BCA ASSESSMENT REPORT

Yennora North West Precinct, Yennora

Client: STOCKLAND

Date: 11 August 2015

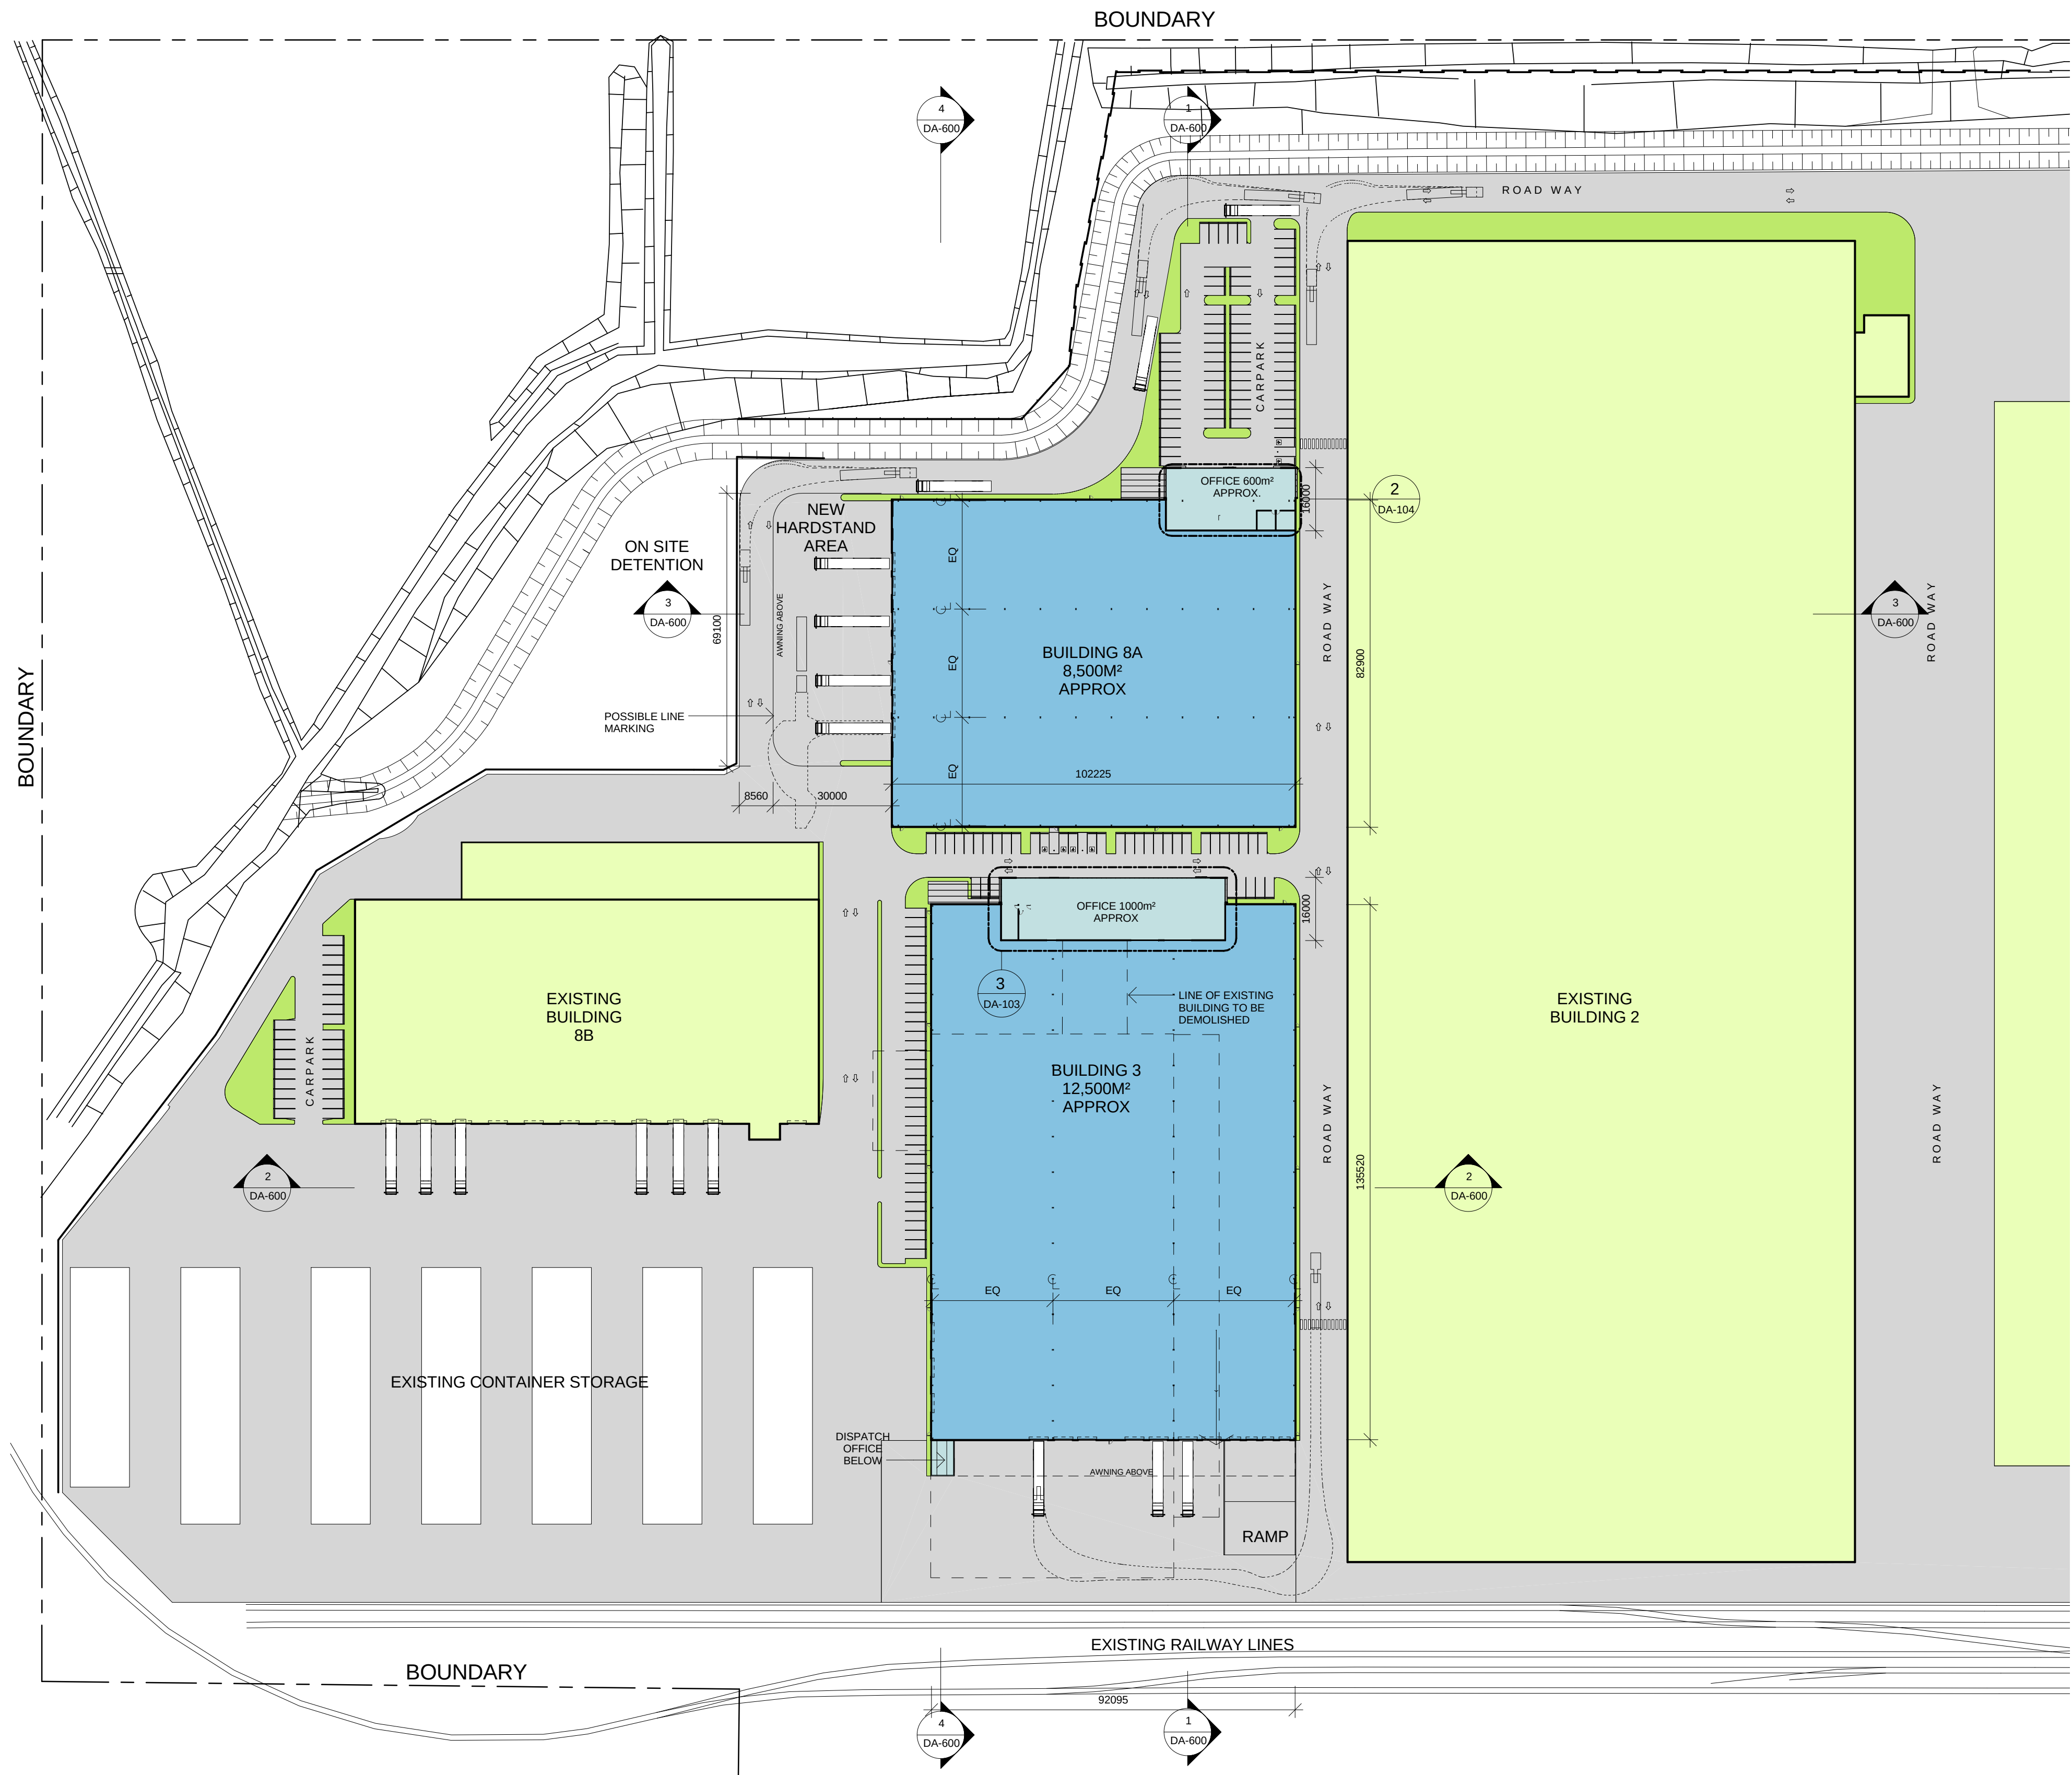
Comments: The proposed warehouse buildings comply with the provisions of C2.4 with the exception of the following:

- Vehicular Access is greater than 18m from the external wall of Building 8A in the north eastern corner.
- Vehicular Access is greater than 18m from the external wall of Building 8A on the eastern façade
- Vehicular Access is greater than 18m from the external wall of Building 3 along the western façade
- Vehicular Access is greater than 18m from the external wall of Building 3 along the southern façade as a result of the ramp in the south eastern corner.

In this regard the above non-compliance is required to be addressed as an alternative solution by the Fire Safety Engineer to demonstrate compliance with Performance Requirement CP9.

Note: The road providing vehicular perimeter access between the two buildings must be designed with adequate loading capacities to withstand a fire truck.
